Ribble Valley Borough Council  
Planning Section  
Council Offices  
Church Walk  
Clitheroe  
BB7 2RA

Phone: 0300 123 6780  
Email: [developeras@lancashire.gov.uk](mailto:developeras@lancashire.gov.uk)  
Your ref: 3/2026/0244  
Our ref: 3/2026/0244/HDC/LB  
Date: 15/06/2026

**Location:** Fooden Hall Farm, Gisburn Road, Bolton by Bowland, BB7 4LS  
**Proposal:** Conversion of existing disused twin barns to 2 dwellings, including removal of derelict farmyard buildings and landscape restoration

DRG NO 31.1/EC

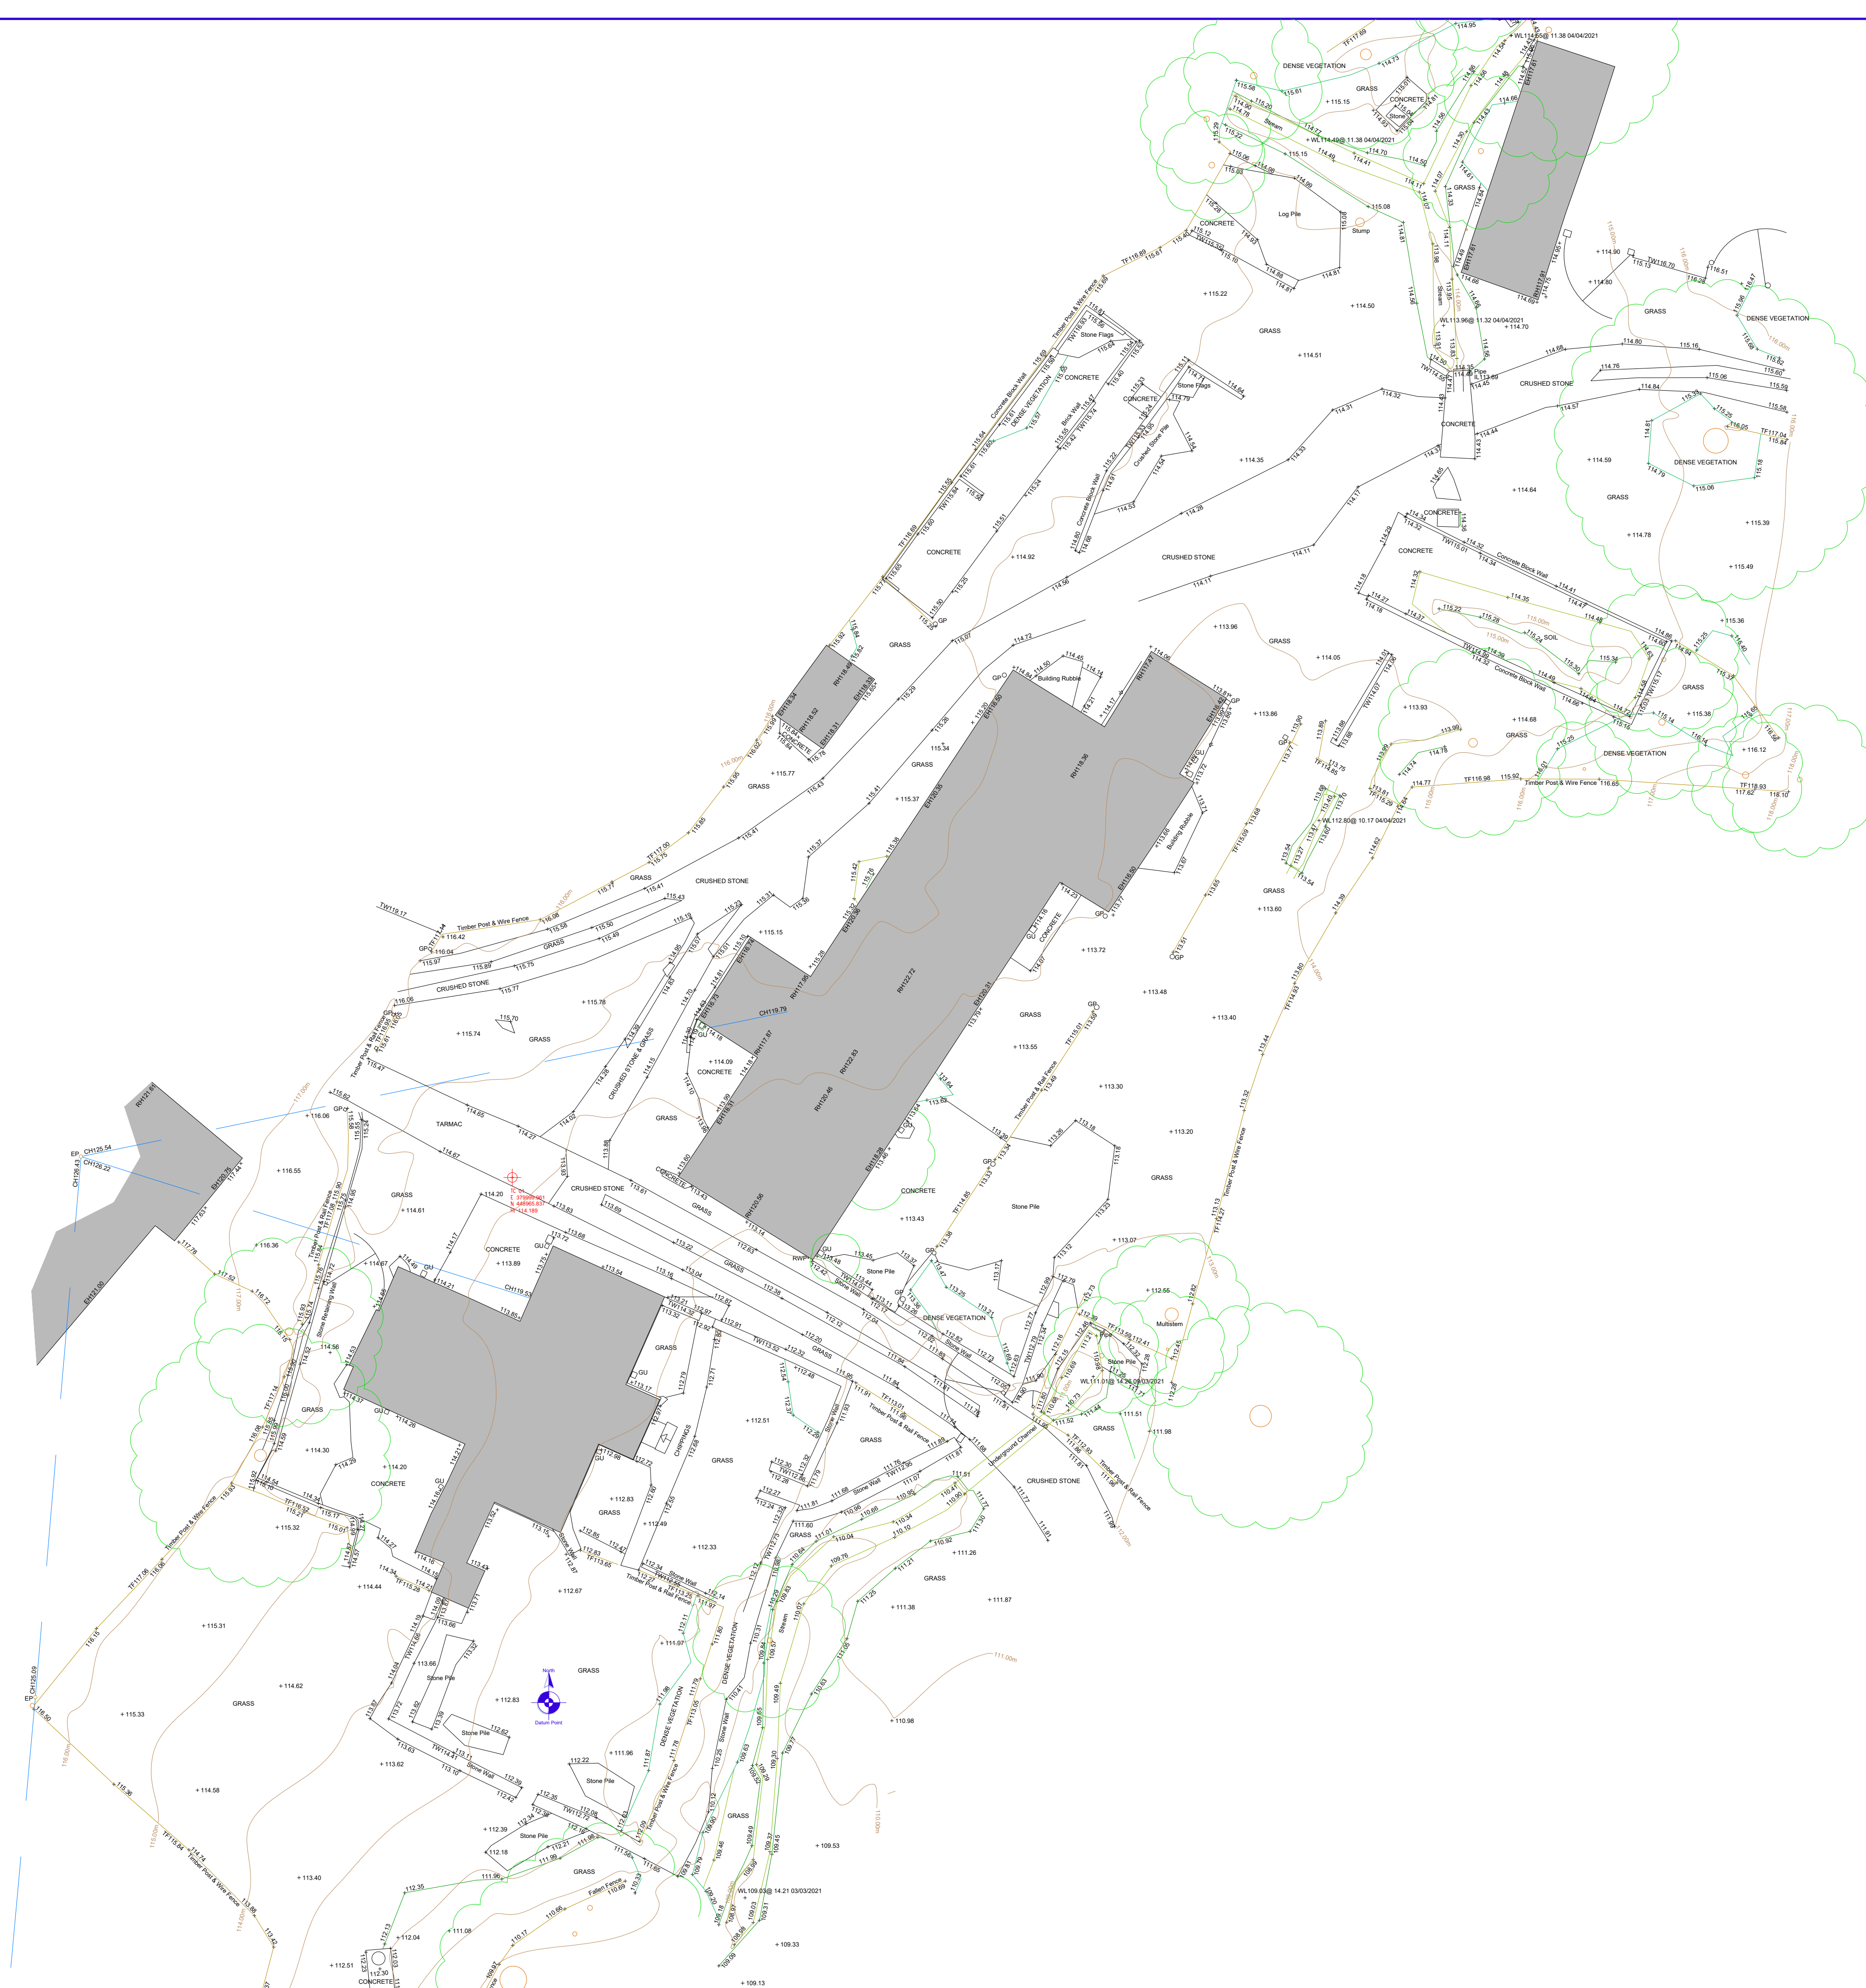
A two-bed dwelling and a three-bed dwelling are proposed. As shown in drawing 'Proposed Site Layout 31.C', there is adequate off street parking provision to support the scale and size of the development.

To promote sustainable forms of transport, secure and covered cycle storage should be provided within the curtilage of each dwelling.

Additionally, to promote sustainable modes of transport, an electric vehicle charging point should be included within the development to serve the proposed dwellings. This shall be fitted in line with the DfT guidance regarding Electric Vehicle Charging in Residential and Non-residential buildings, which states - charge points must have a minimum power rating output of 7kW, be fitted with a universal socket that can charge all types of electric vehicle.

The proposed visitor parking spaces are shown to have a new tree to the left and a hedge to the right of the spaces. Please be advised that they should not interfere with site lines/visibility when utilising the spaces, as Public Right of Way (PRoW) footpath FP0307028 runs along the track past the development. We advise a hedge height no greater than 0.9m.
